**HONOR CHARTER**  
**ACADEMY**  
 BENT GRASS MEADOWS DRIVE  
 PEYTON, CO

SCHEMATIC LANDSCAPE PLANTING PLAN

LP-1

LP-1

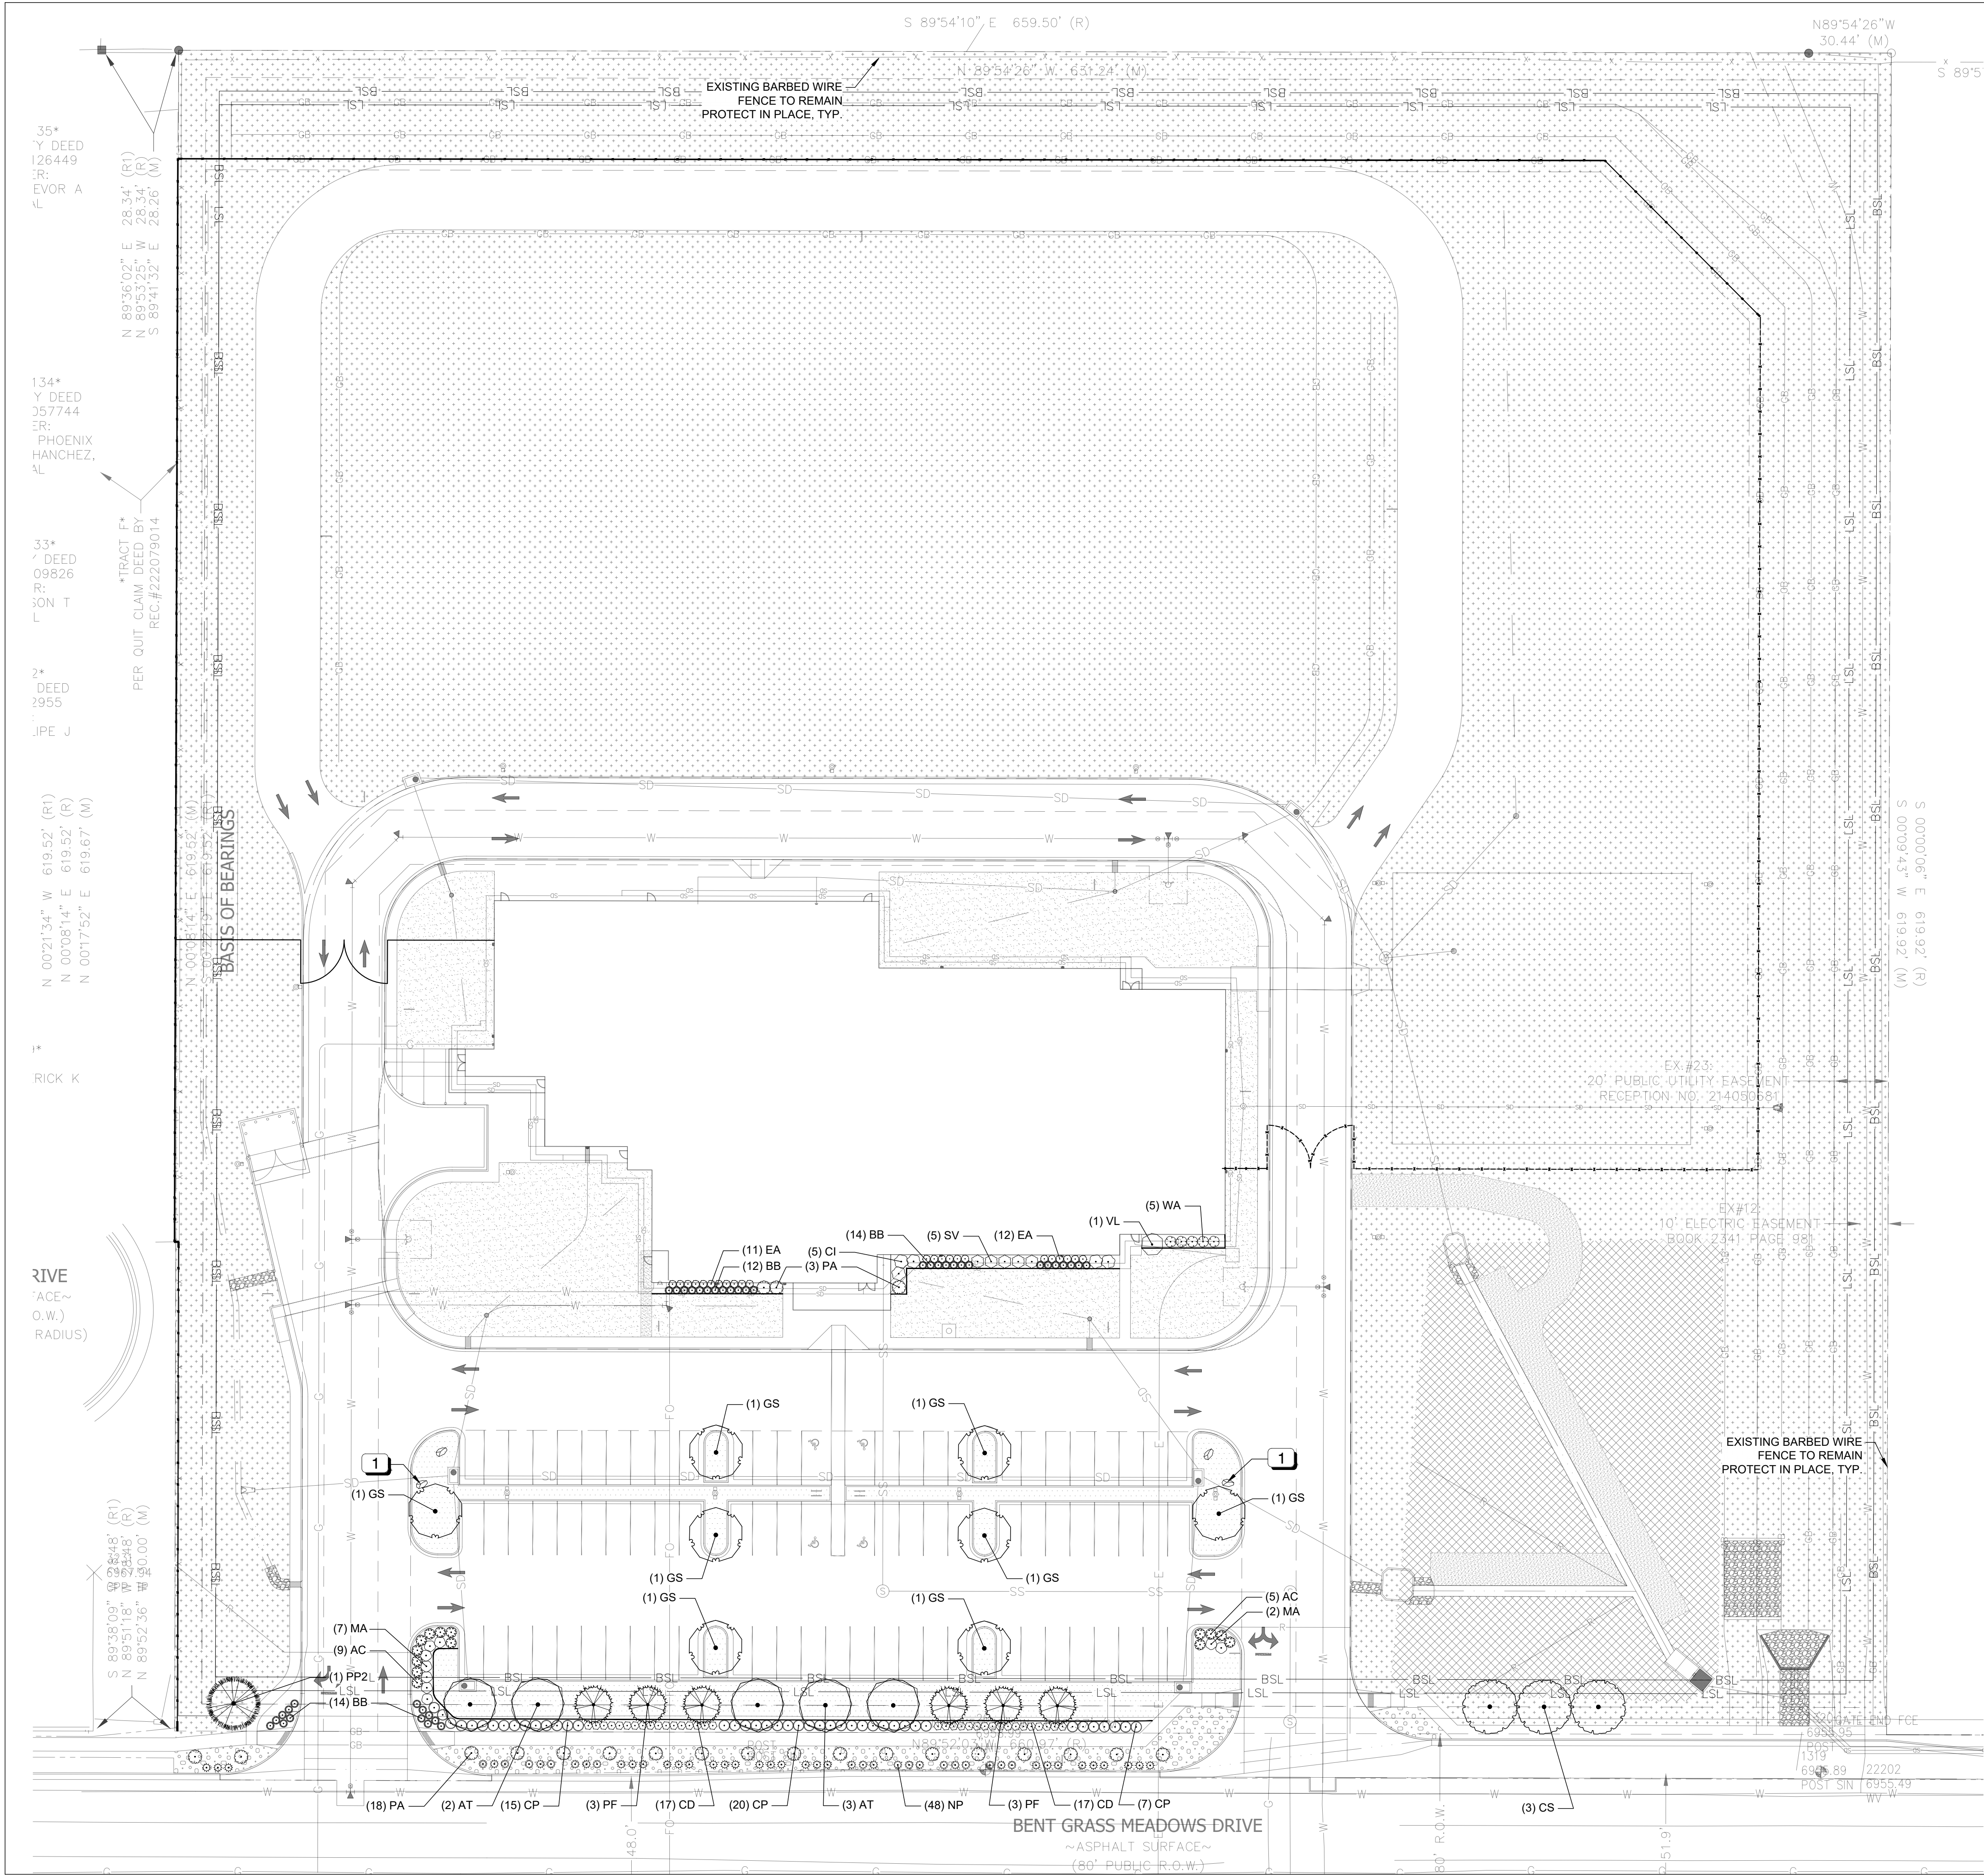
Please review the landscape requirements of the Code and provide the buffer, parking, internal and roadway categories

Please review landscape checklist and add all missing items

Show all property lines and depict 25 foot building setbacks, and provide landscape, buffer setbacks per Chapter 6
